Ribble Valley Borough Council
By email

Your ref 3/2025/0696
Our ref DC/25/2478
Date 06-OCT-25

Location: Markhor Eaves Hall Lane West Bradford BB7 3JG
Proposal: Erection of new dormer bungalow on existing residential site, to replace existing bungalow (to be demolished)

Proposed Site Plan
1:200 Scale

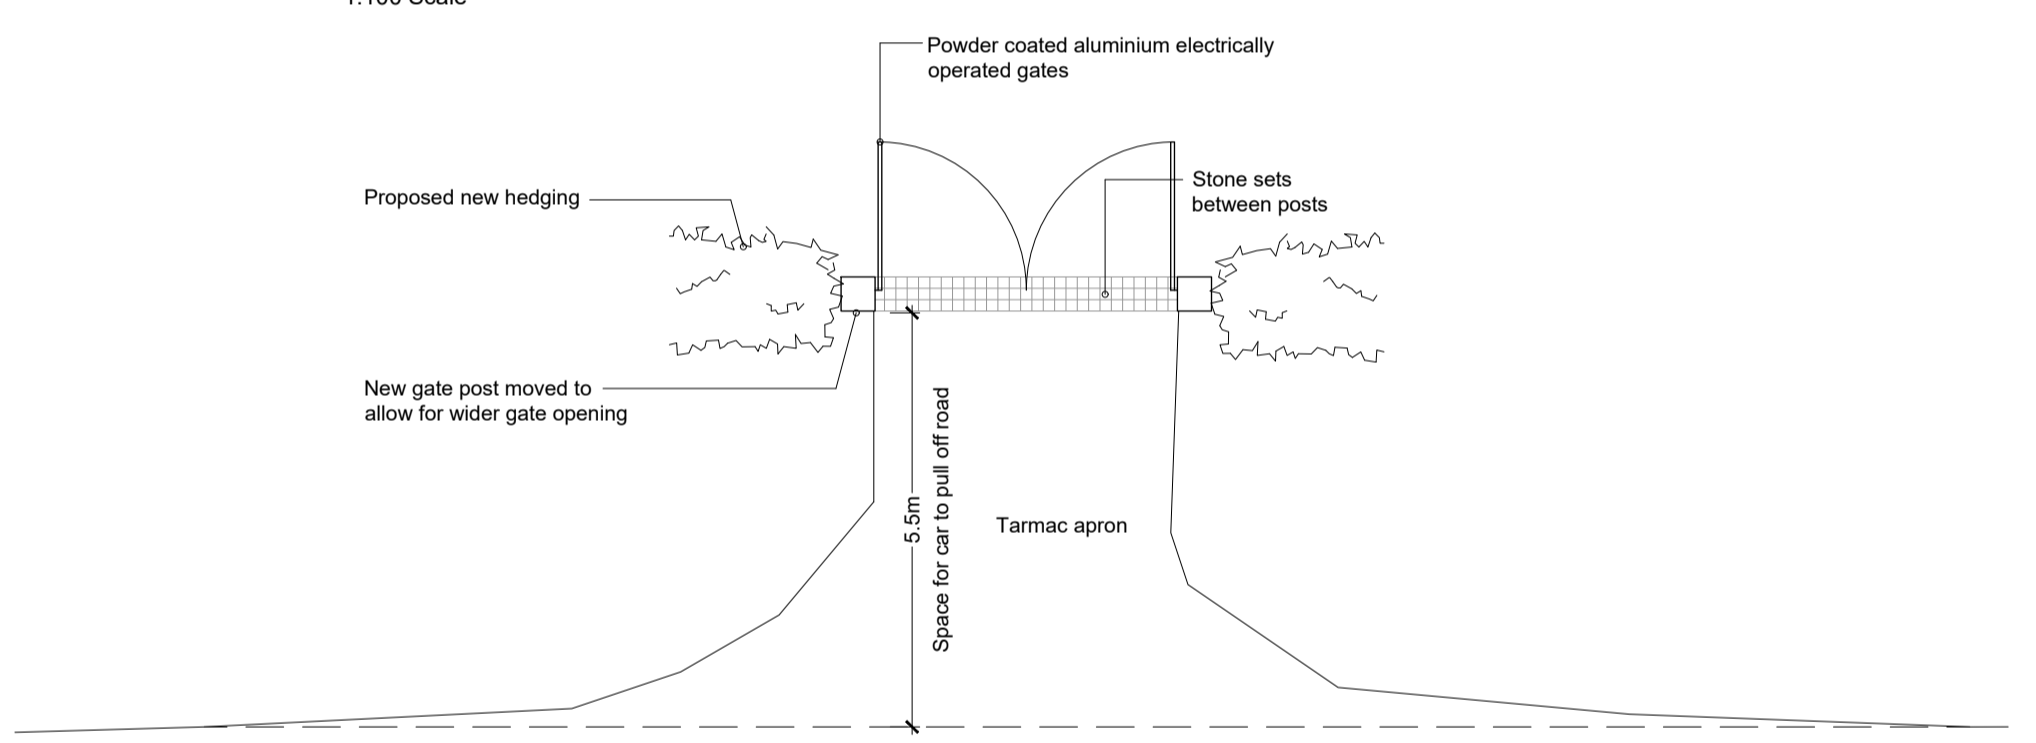
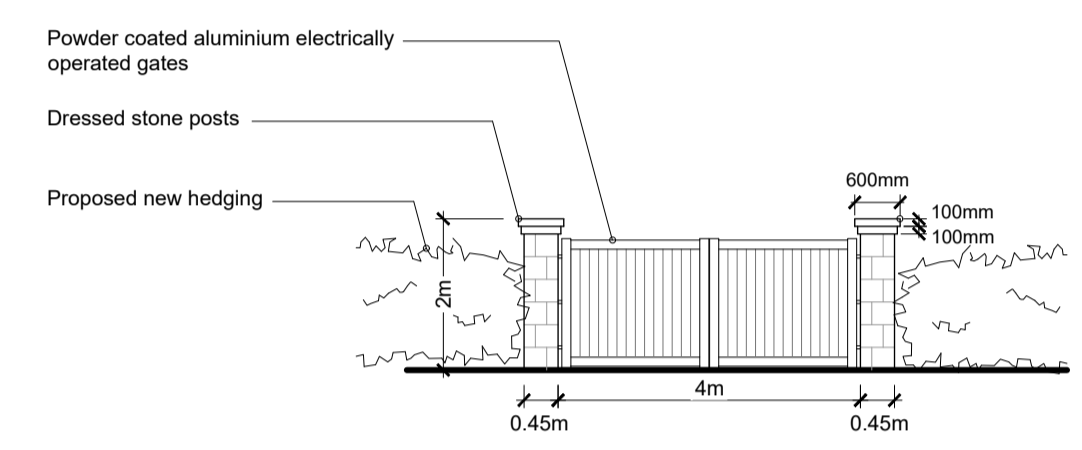
Following our review of the proposed site layout, Drawing No: 7125-P06, REV: D, Date: 01.09.25, it appears that our access to the sewer may be compromised and this will require resolution by the applicant. We recommend the applicant seeks advice on this matter from our Developer Services team at the earliest opportunity as a diversion of the affected public sewer may be necessary.
